Recommendation Report for Planning Permission

REF NO:	AL/81/21/PL
LOCATION:	Ryefields Farmhouse Oak Tree Lane Woodgate PO20 3GU
PROPOSAL:	Demolition of existing building & erection of 5 No houses comprising 1 No 4-bed detached, 2 No 4-bed link detached & 2 No 3-bed detached houses with associated access & parking (resubmission following AL/72/19/PL). This site is in CIL Zone 1 & is Zero Rated.

Figure 1.3: Proposed Site Layout

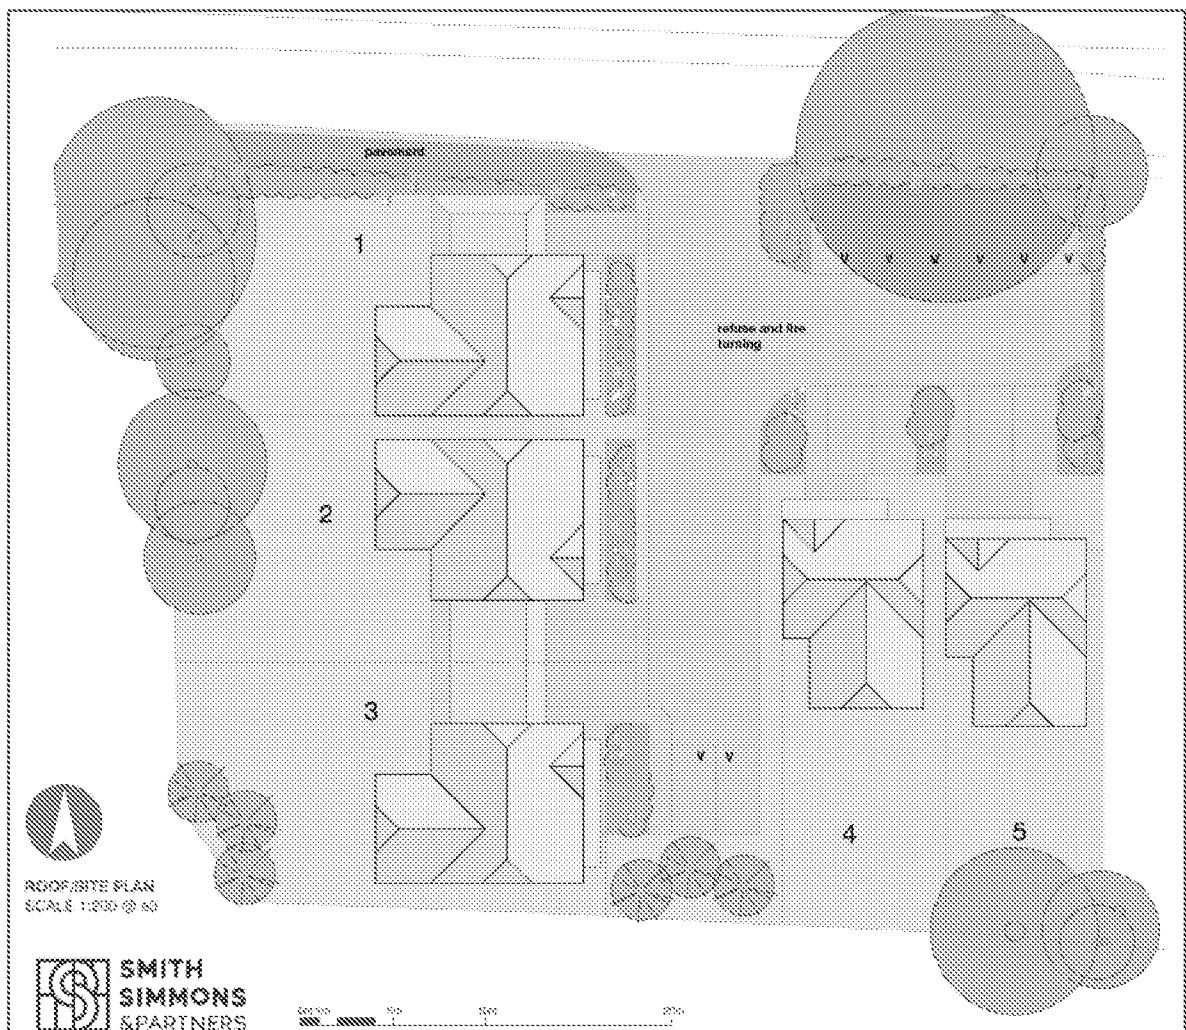
Conversely, the application proposal seeks a different urban form of a cul-de-sac development where the side elevation of plot 1 would be situated some 2.5m from Oak Tree Lane would be readily visible from Oak Tree Lane. This would erode the established form, continuity and cohesion of the street scape along Oak Tree Lane.

The design and layout of the site is further exacerbated through the inclusion of the visitor parking bays along the boundary of Oak Tree Lane, which comprises 6 no. spaces arranged in a bay parking formation. Such a parking arrangement directly conflicts with the established parking layout of residential buildings off Oak Tree Lane, where off-street parking is accommodated forward of the primary elevations of dwellings.

The provision of the bay parking arrangements, combined with the absence of an established set back which defines the character and appearance of the area, is an erosion of a clear and consistent character and appearance of the area and is indicative of intensification of development resulting in cramming.

FIGURE 1.4

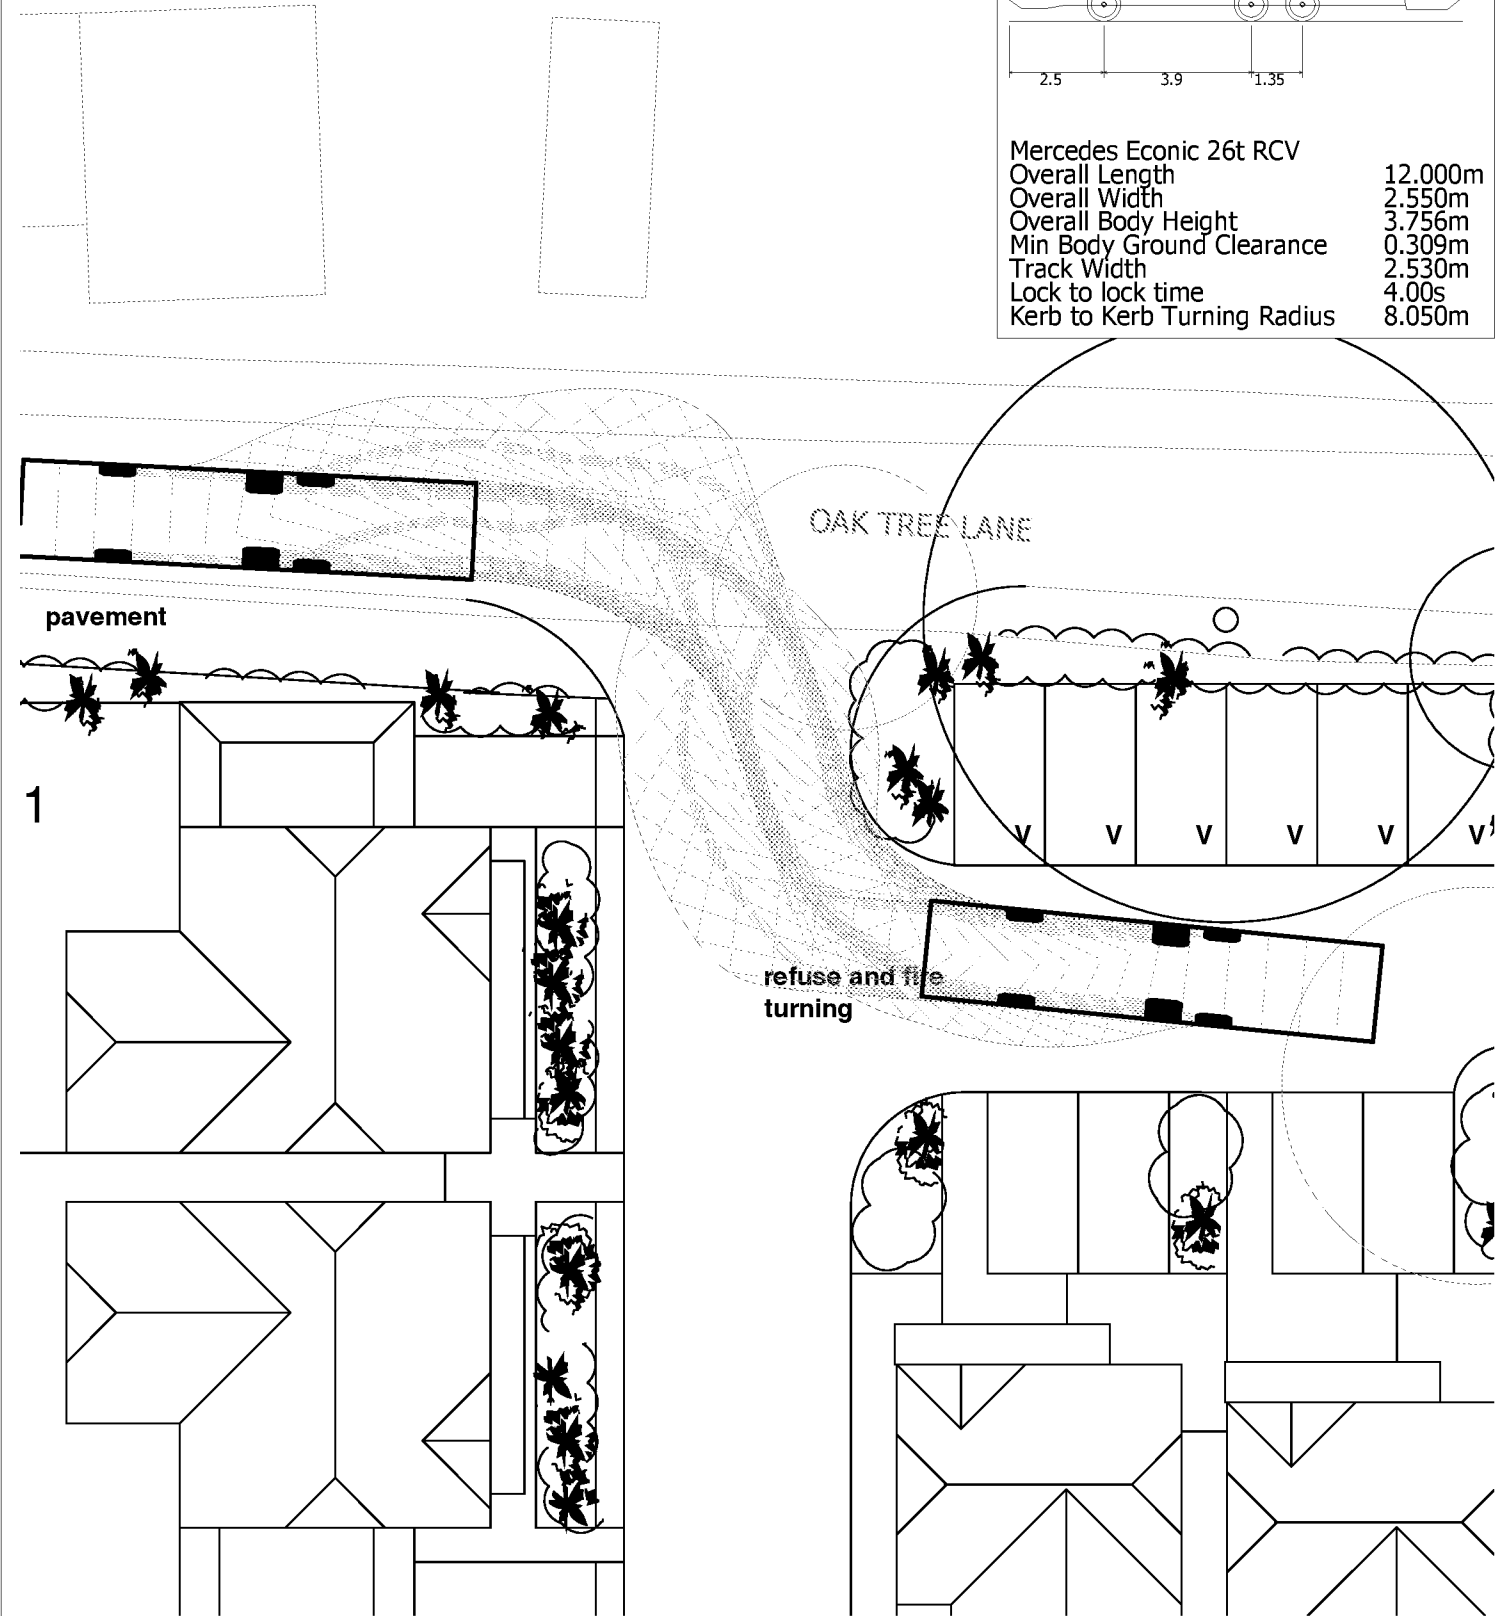
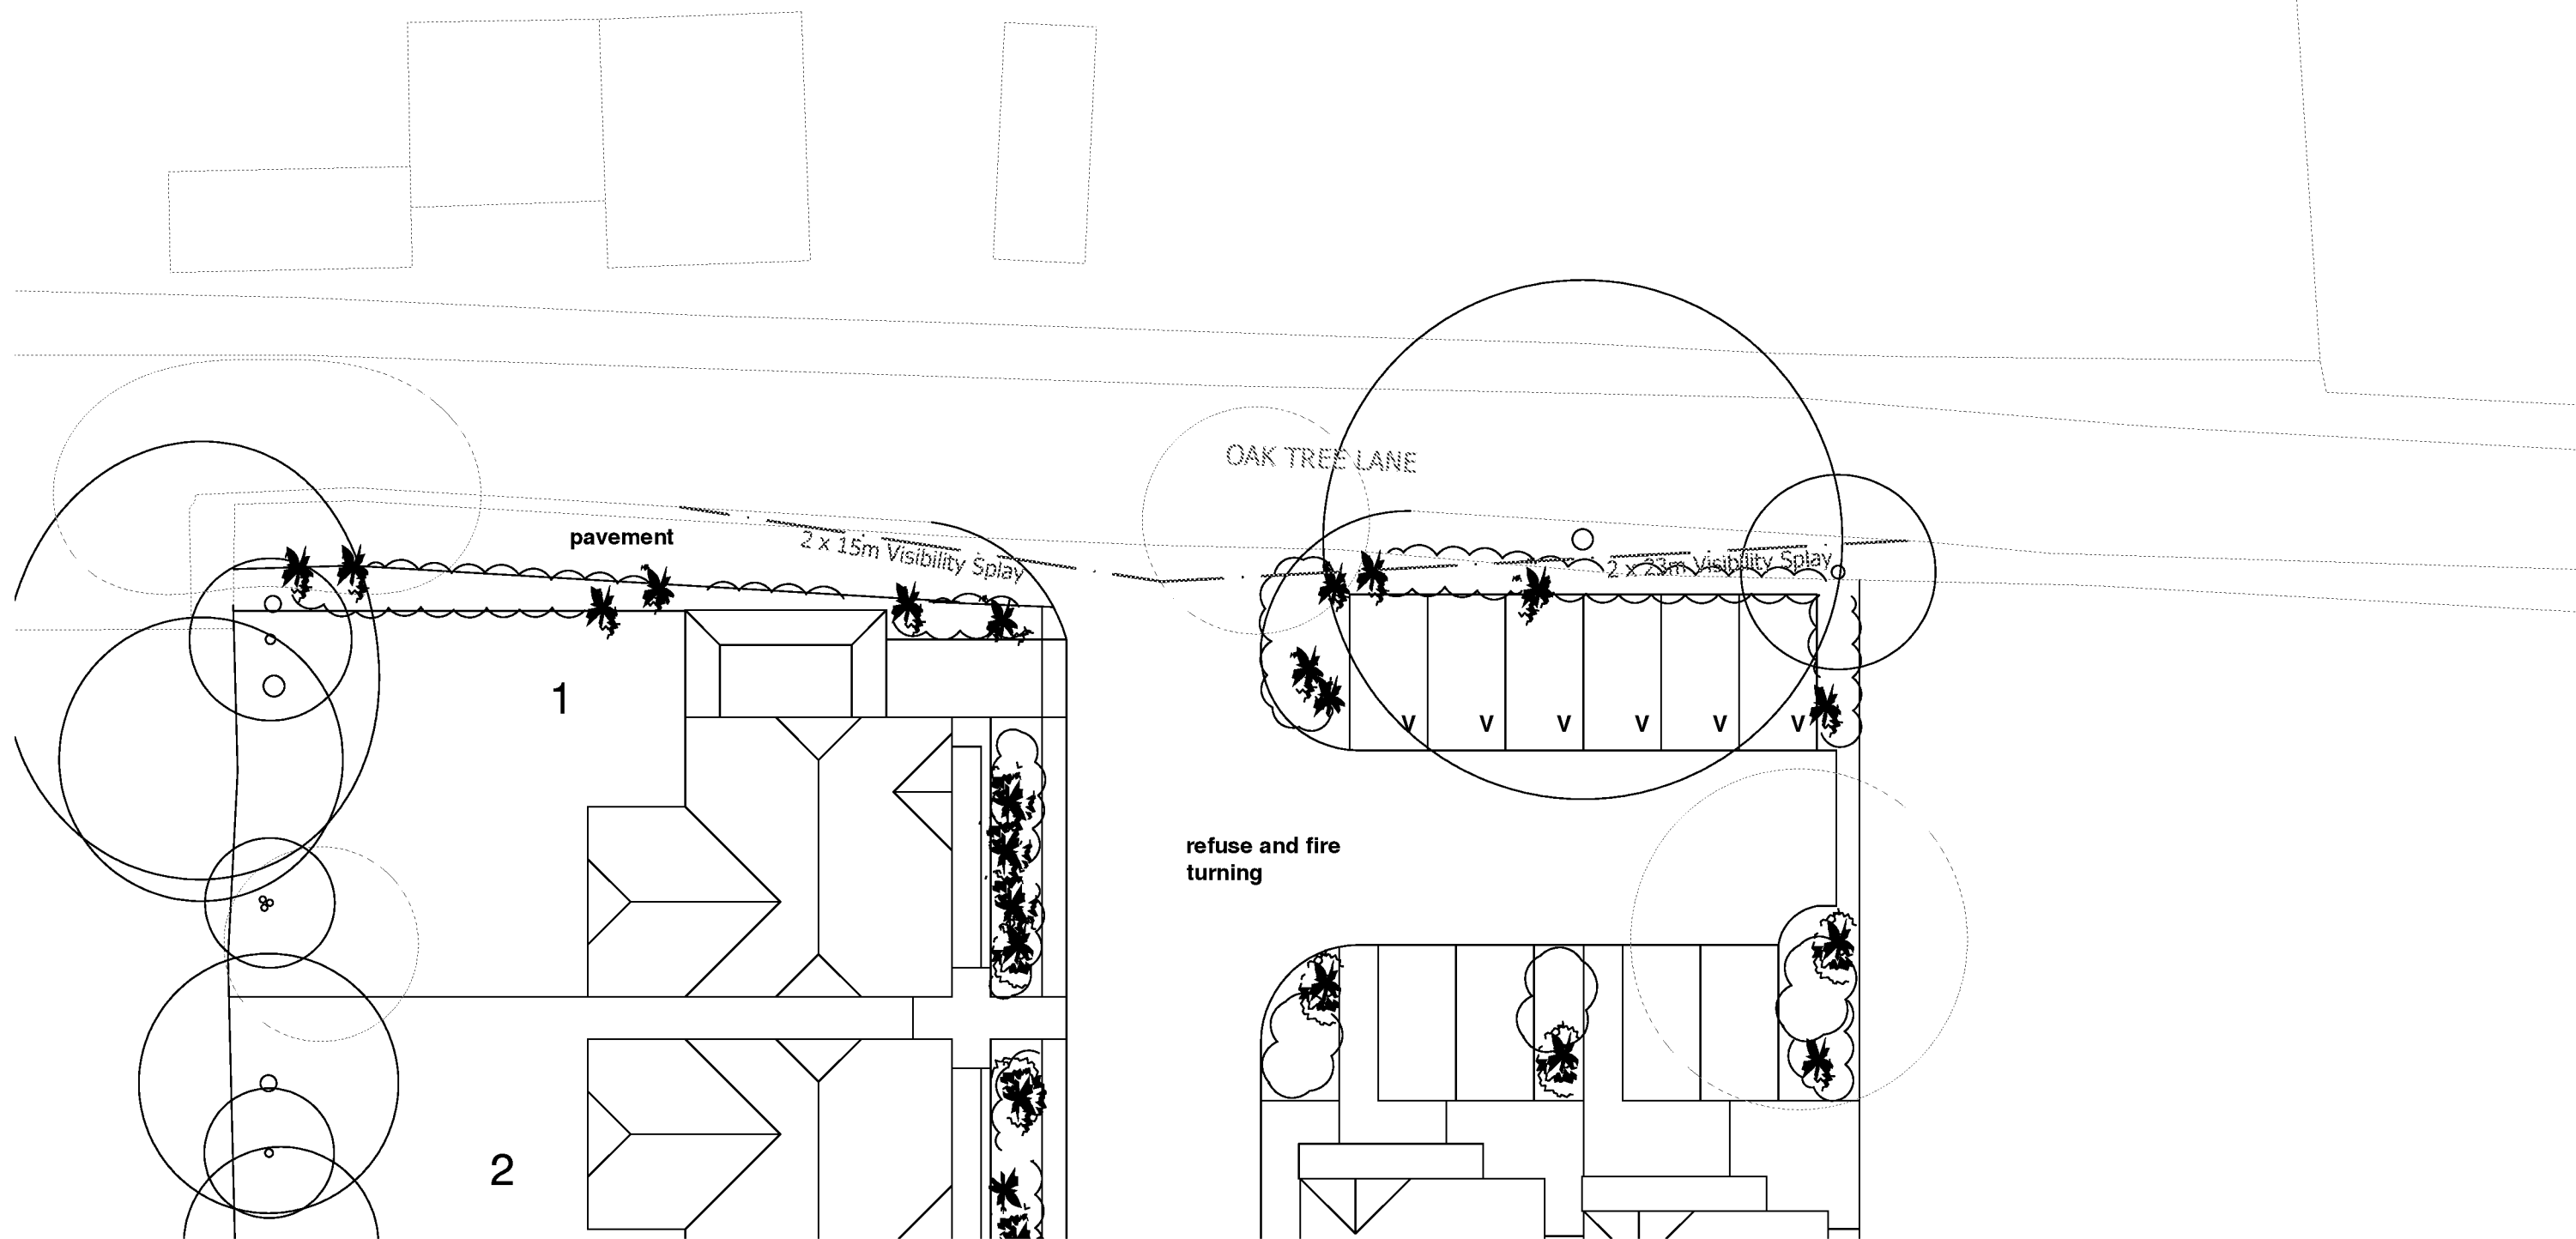
- Reeds Lane is only 3m wide and does not comply with Building Regulations for the access for fire services in the event of an emergency.
- The swept path analysis for a large refuse vehicles looks very tight.

ROOF/SITE PLAN
SCALE 1:200 @ a3

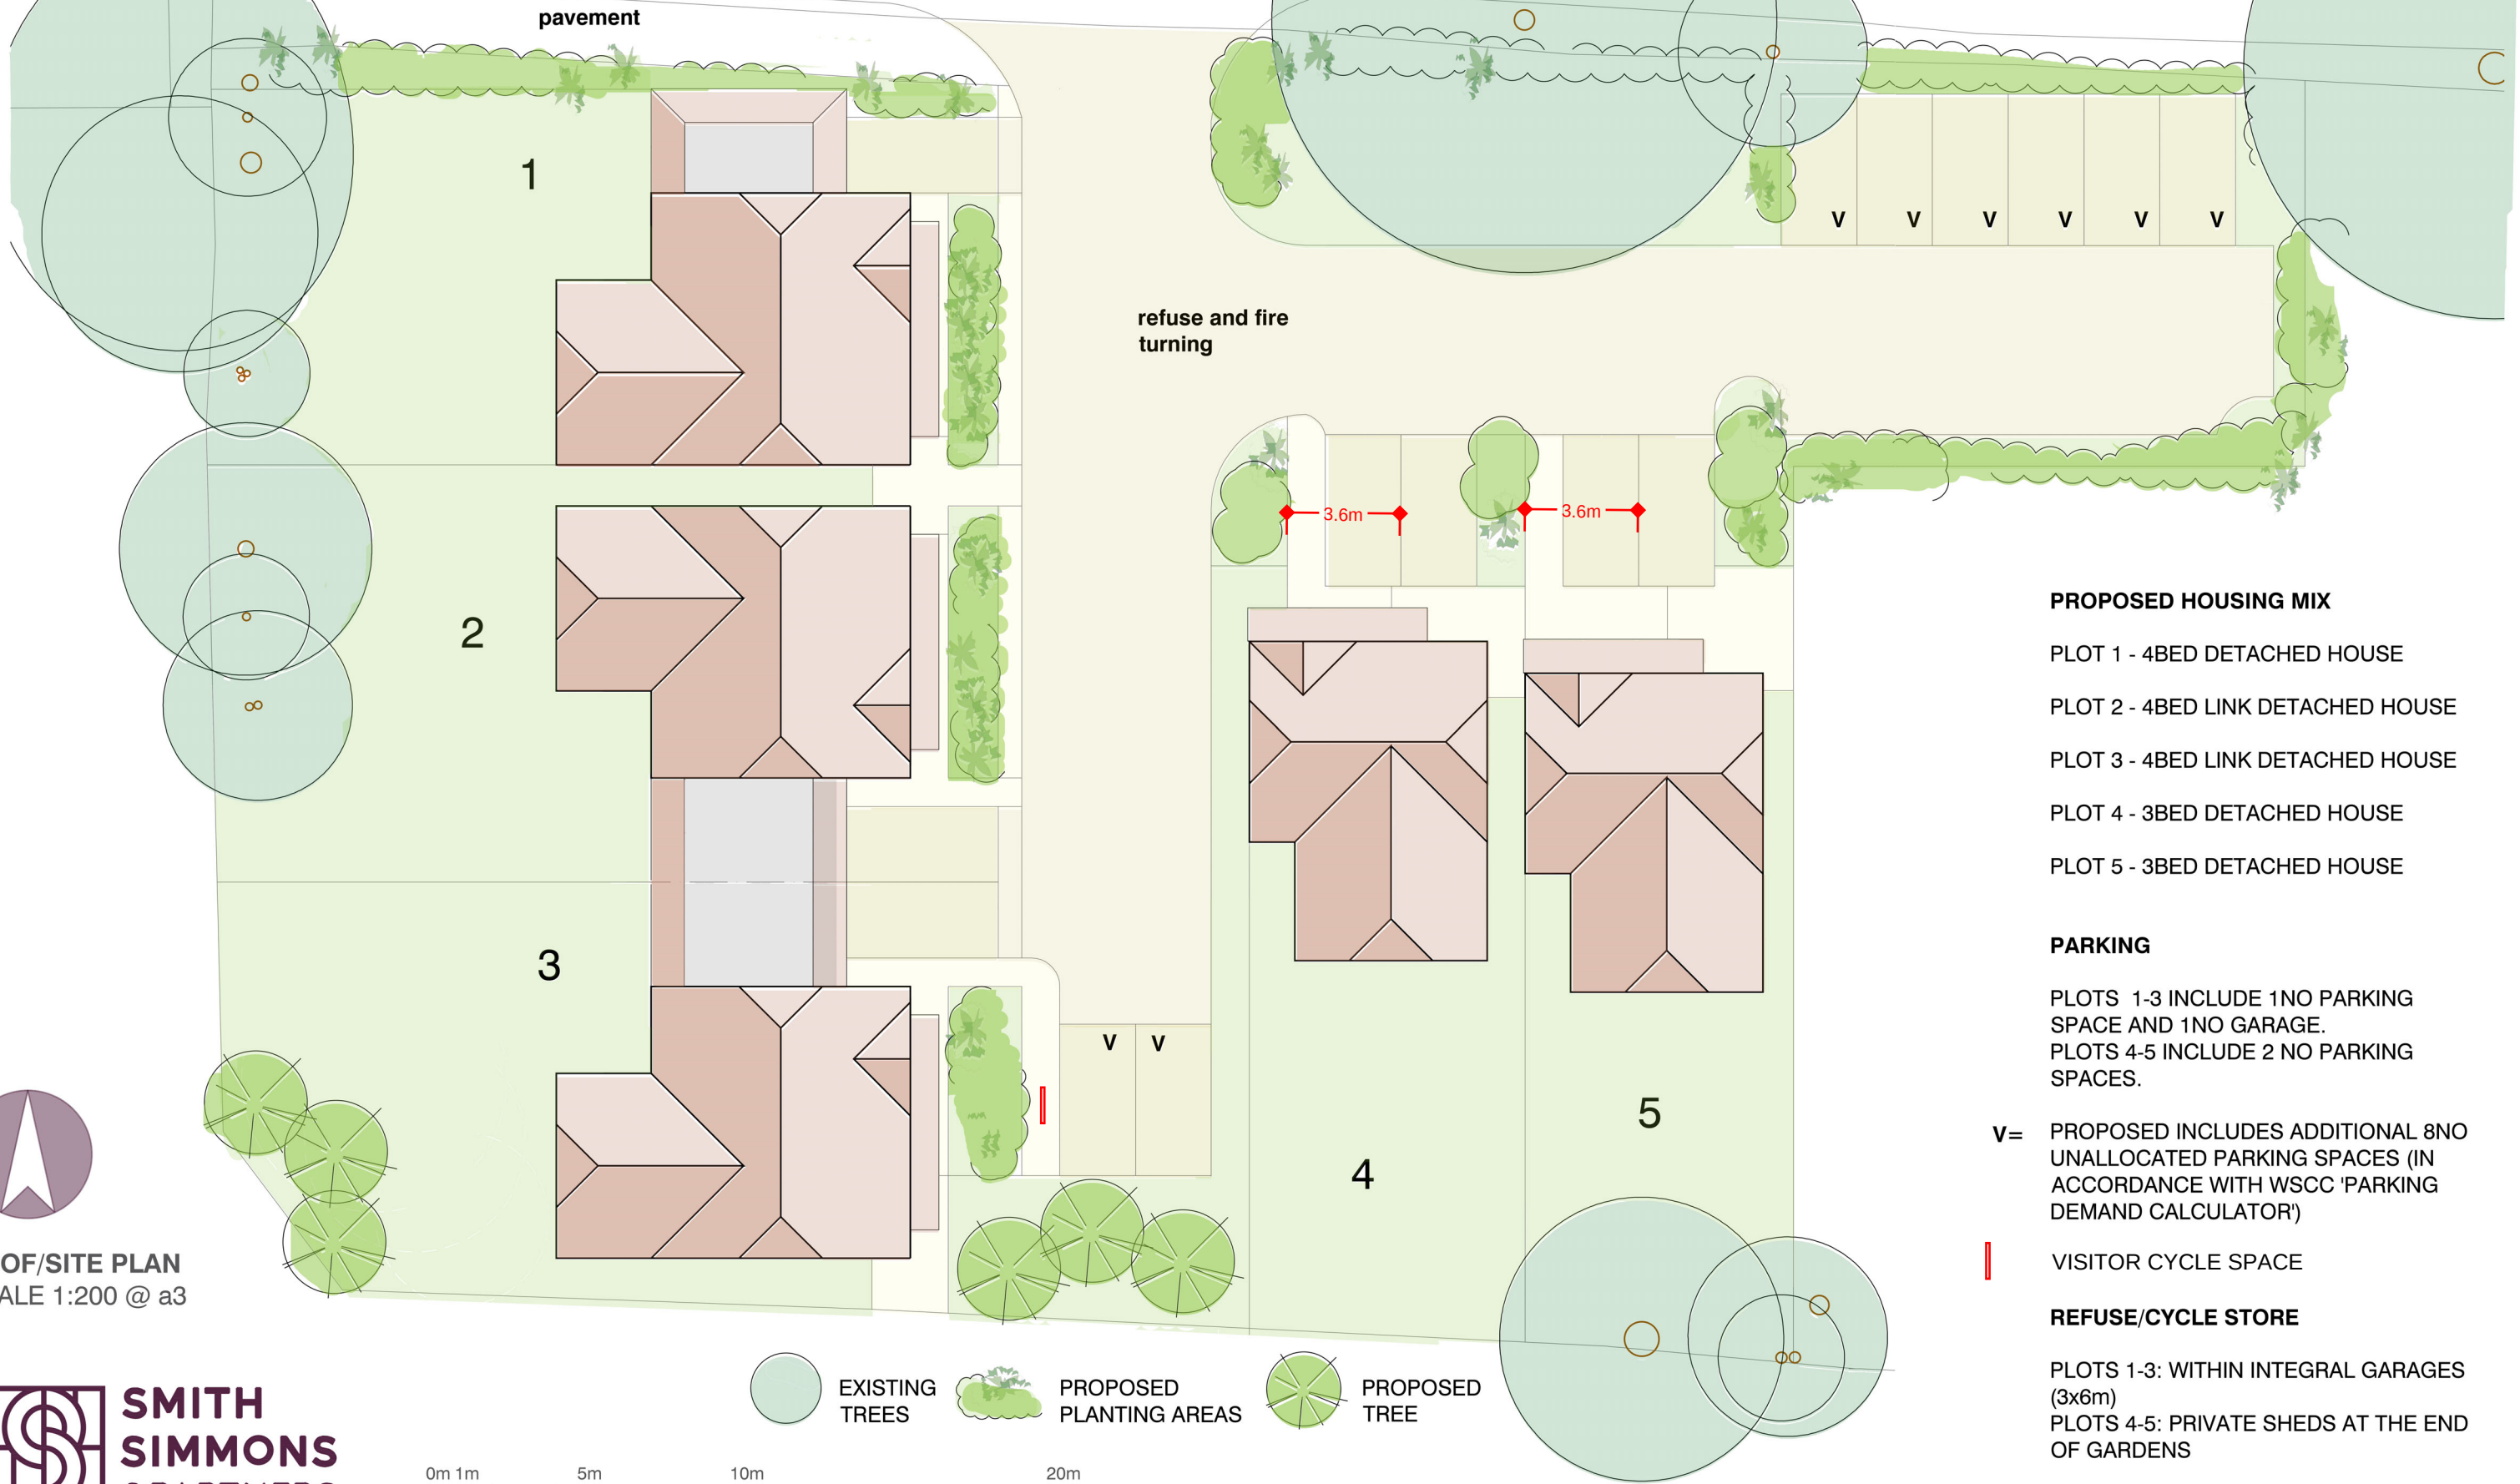
'I find this latest application to be ill-conceived in arboricultural terms and layout inferior to that previously submitted. I cannot support the removal of principal off-site tree (oak - T20) to facilitate any scheme for this plot. A development that respects and accommodates the higher quality trees and those of long-established landscape value is achievable, yet there is no aspiration to do so here.
